**KIRKLEES METROPOLITAN COUNCIL  
INVESTMENT & REGENERATION SERVICE**

**DELEGATED DECISION TO DETERMINE PLANNING APPLICATIONS**

| Reference No:         | <b>2021/62/91597/E</b>                          |
| Description:          | Erection of electronic gates                    |

ELEVATION TO UPPER ROAD

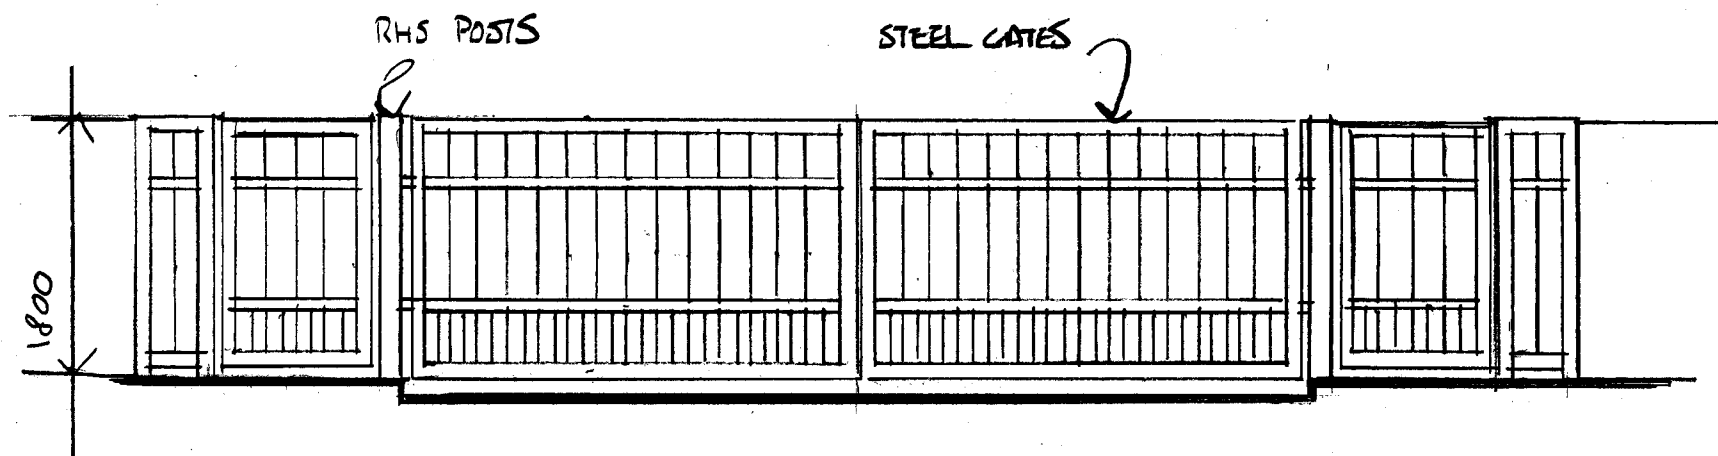
The existing housing development is set back from the public highway and arranged into two terraces facing inwards to a turning head. The proposed gates would be situated at the access to this turning head. At some 1.8m in height, they would appear prominent and incongruous within the streetscene.

The gates have been set back 6m from Upper Road which is a sufficient area to avoid stopping on the highway whilst the gates open. The gates should only be set to open inwards, and this should be controlled by a condition.

1. The proposed gates would result in the creation of a gated community development, which would not integrate with the street scene, nor respect the character of the wider area. Development surrounding the application site is left open, with limited, or low-level boundary treatments visible when viewing from public land. The proposed boundary treatment for the approved development would not reflect this character and would cause less than substantial harm to the setting of the nearby Grade II listed building to the east. The proposed development would therefore be contrary to Policies LP24 and LP35 of the Kirklees Local Plan.
